Demolition of promenade shelter & construction of cafe & kite surfing school with roof terrace & associated works

Promenade Shelter Sea Road Littlehampton

Thank you for your internet representation made on 31st October 2017 which has been recorded as '**an objection**' with the comments as follows:

First floor plan | proposed

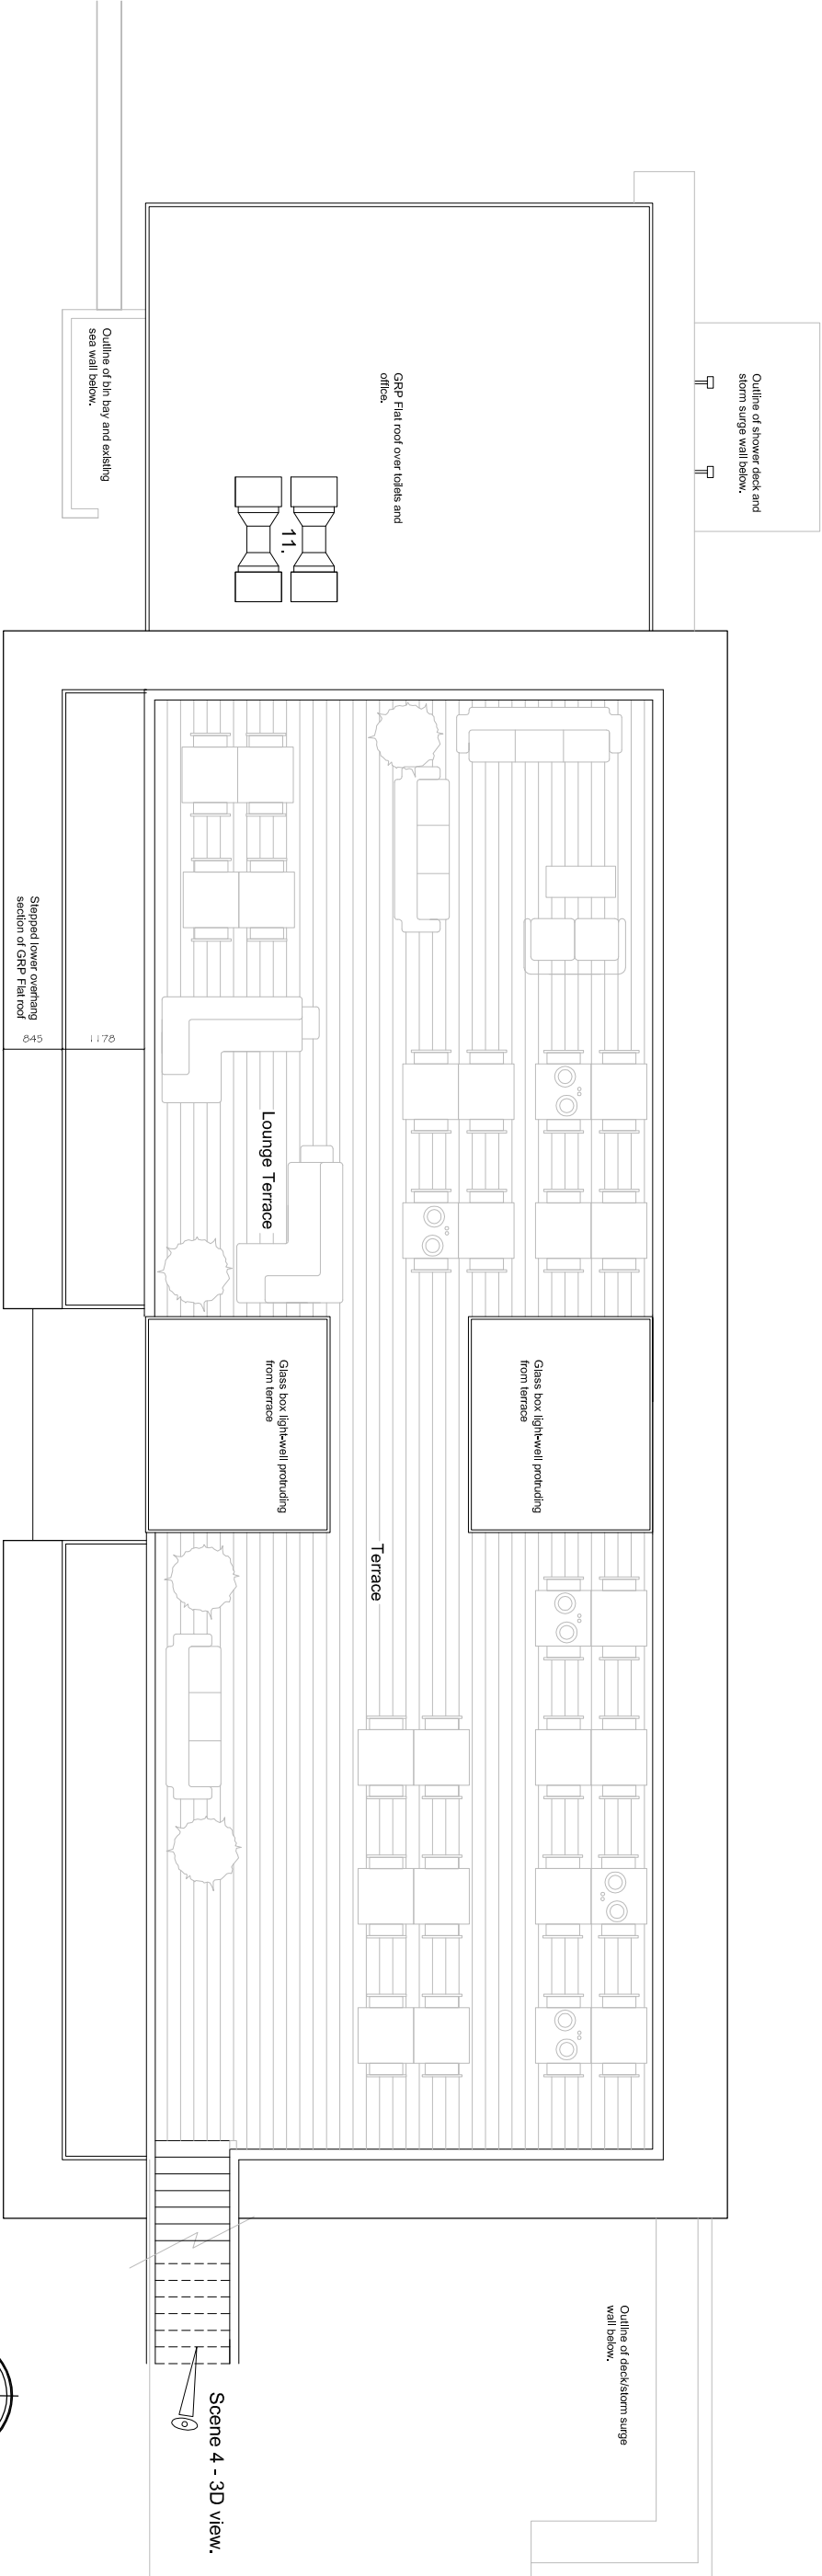
Firstly as Much as I am in favour of the removal of the current shelter and something new and iconic being put or built in its place I am objecting to the application for the reasons of that the new building that is proposed is boring , bland and aesthetically boring to the eye . If it is supposed to be a wind surfing shop / kite surfing at least design the building to replicate such an item . I am also concerned about the amount of hurdles that the disabled are going to deal with to gain access to the toilet according to the floor plan surely this can be addressed to make it easier . I am also asking is there disabled access to the 1st Floor viewing area as I cannot see this on the plan . I see steps but no wheel Chair access , The disabled have just the same rights to be able to access a viewing area as a able bodied person so why no access ?
